Rezoning Transportation Analysis

Petition Number: 2021-080

Date	Description
08-02-2021	First Review (KP)
08-23-2021	Second Review (KP)

PROJECT NO.:	MRE-13040
FILENAME:	
DESIGNED BY:	BGP
DRAWN BY:	BGP
SCALE:	
DATE:	12-15-2017
SHEET NO.:	RZ-1

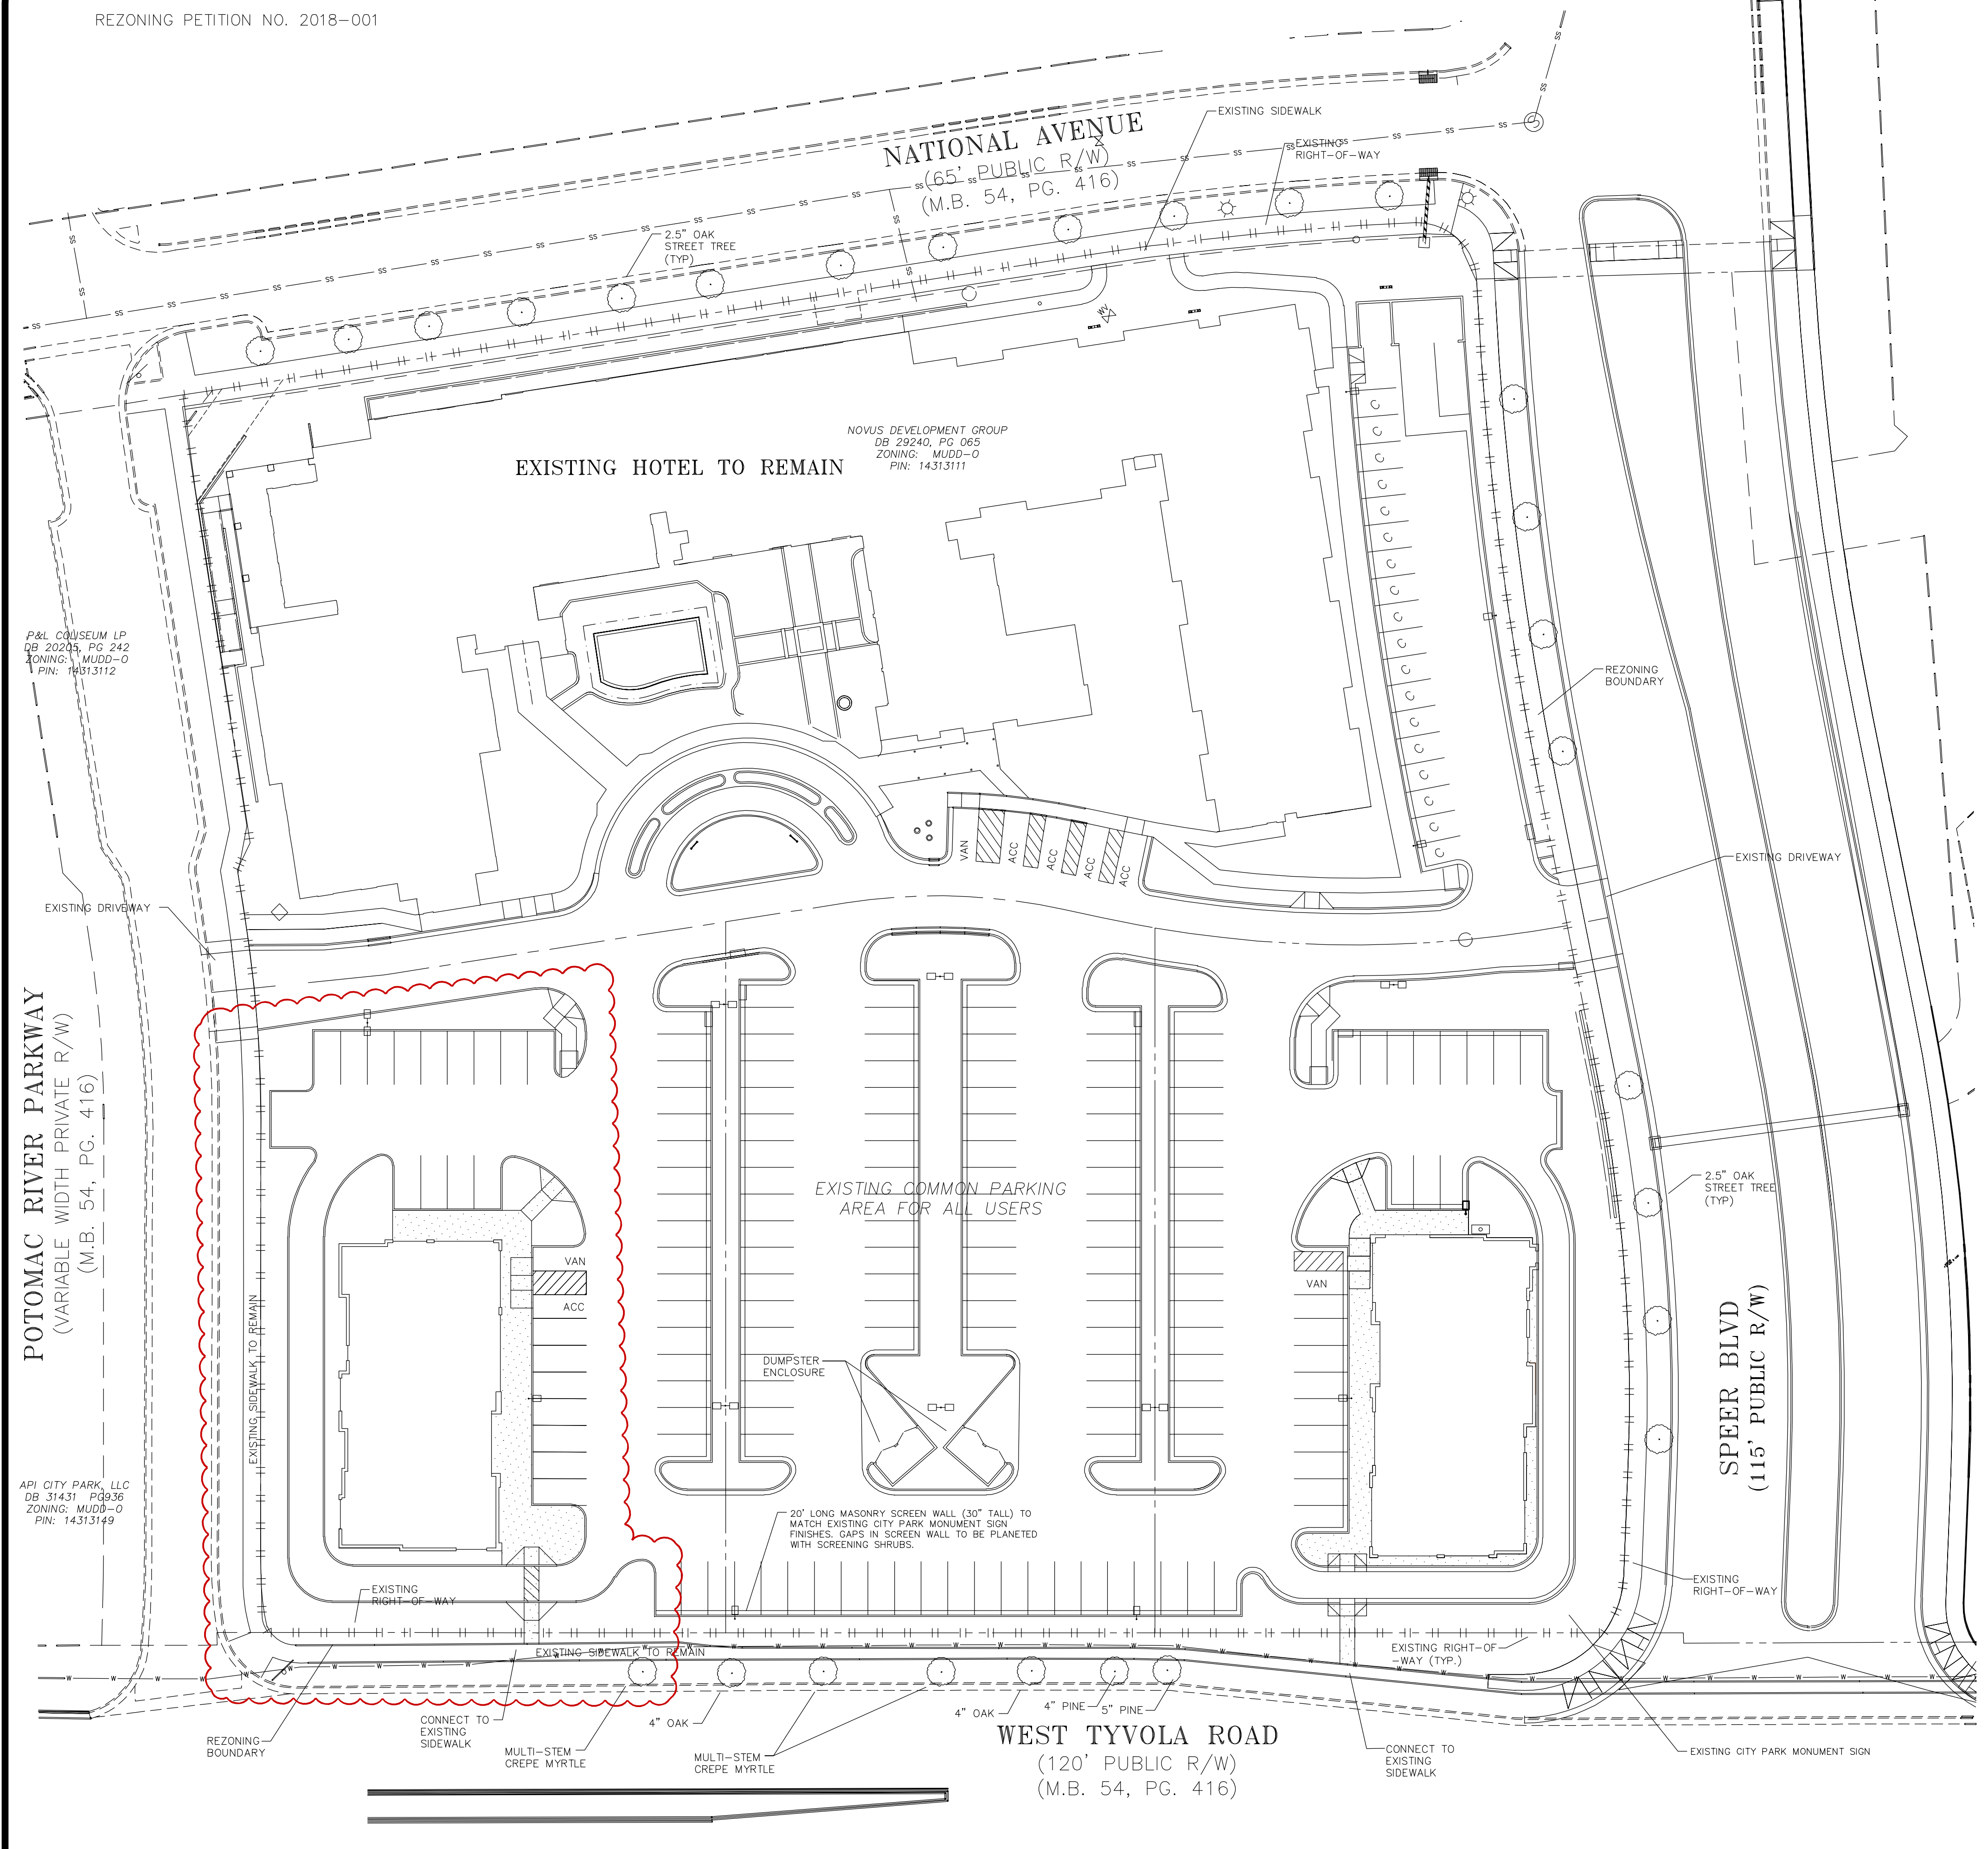
~~2. Revise rezoning sheet RZ-1 to accurately reflect the existing striping on Speer Boulevard and removing the traffic signal at the intersection of Speer Boulevard and Tyvola Road.~~

PROJECT NO. MRE-13040  
 FILENAME: MRE13040-S1  
 DESIGNED BY: BGP  
 DRAWN BY: BGP  
 SCALE: 1" = 30'  
 DATE: 12-15-2017  
 SHEET NO. **RZ-2**

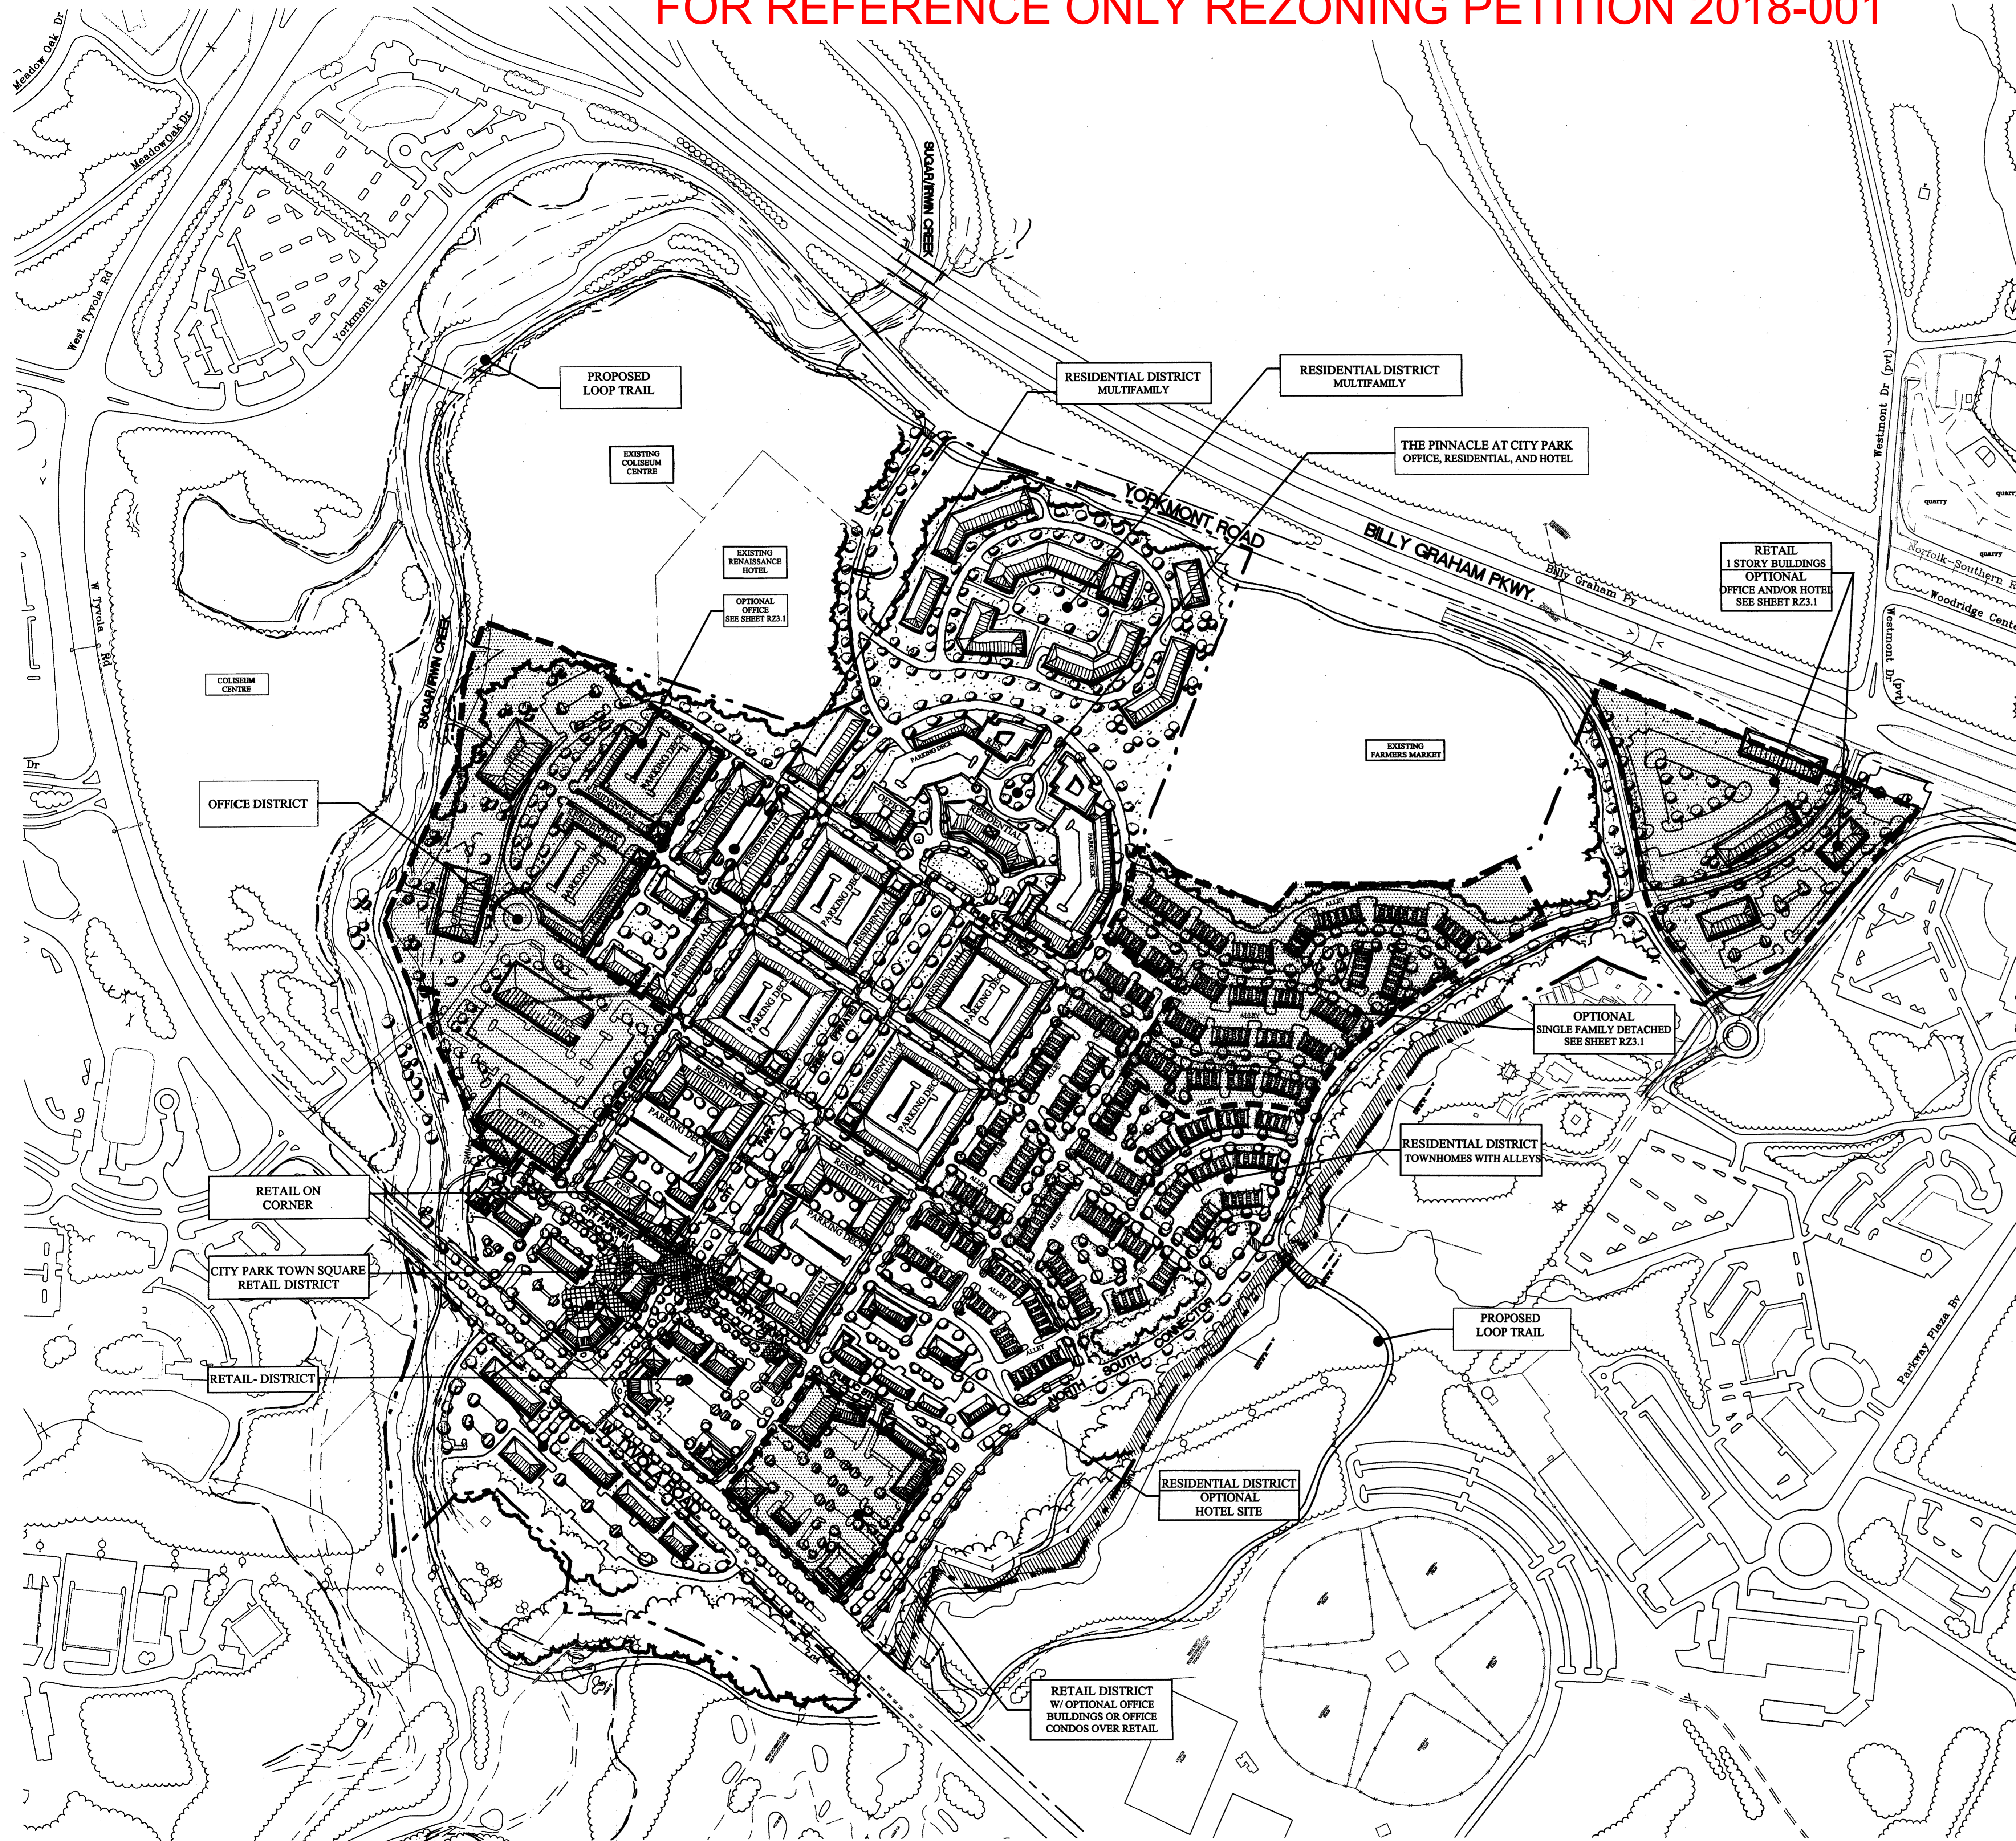
3. Revise rezoning sheet RZ-2 by completing, and including, the following tracking table for the transportation improvements established in the original 2007-082 rezoning. Pending the table's completion and CDOT's review, CDOT may require any incomplete transportation improvement(s) to be included as a part of this petition and completed upon development of this site.
